To: Perry Mose
CC: Joseph Alessi, PLS, CRA, GRI, BSME Alessi and Associates, Inc.
From: Julia M. Murphy, MS PG/GWI Professional Geologist/Hydrogeologist
Date: February 15, 2021
RE: Response to Comments: Jeanette Mose Minor Subdivision

The following are responses to questions on the portions of the Subdivision submittal that Groundwater Investigations LLC prepared or was associated.

# Jeanette Mose Subdivision

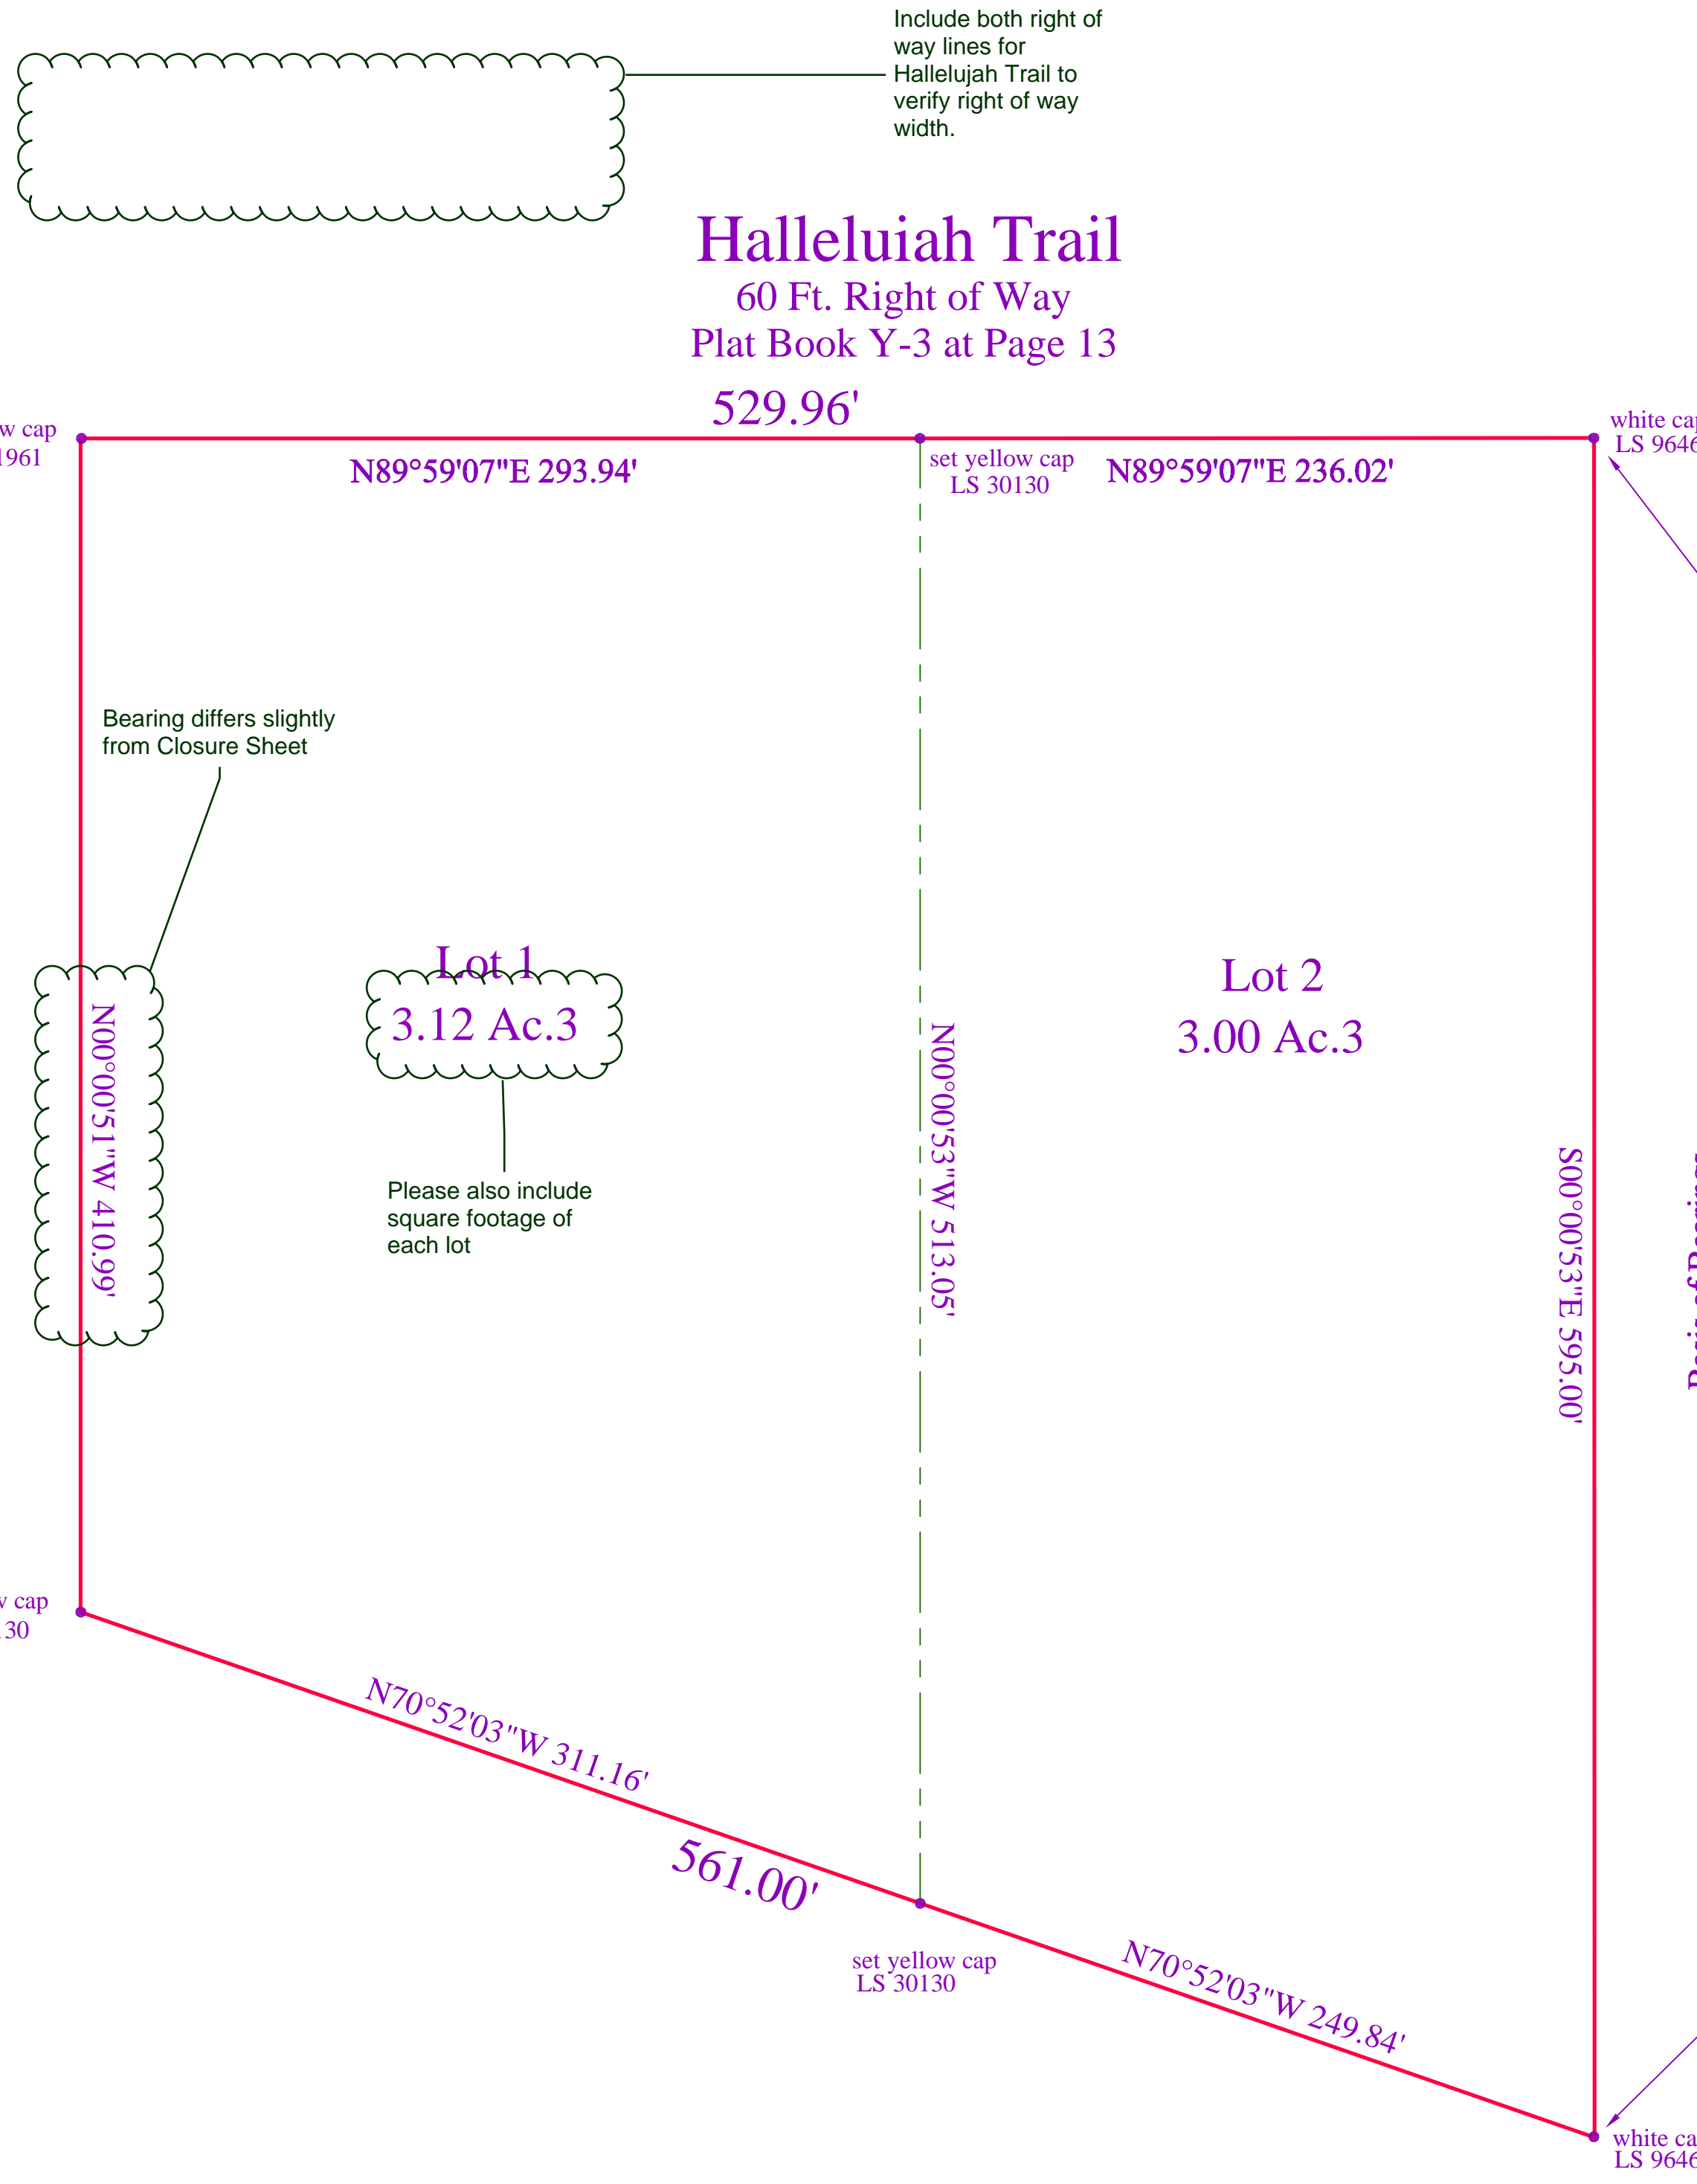
- 1. ***Acreage is incorrect or referencing different property***

Response: Acreage has been corrected
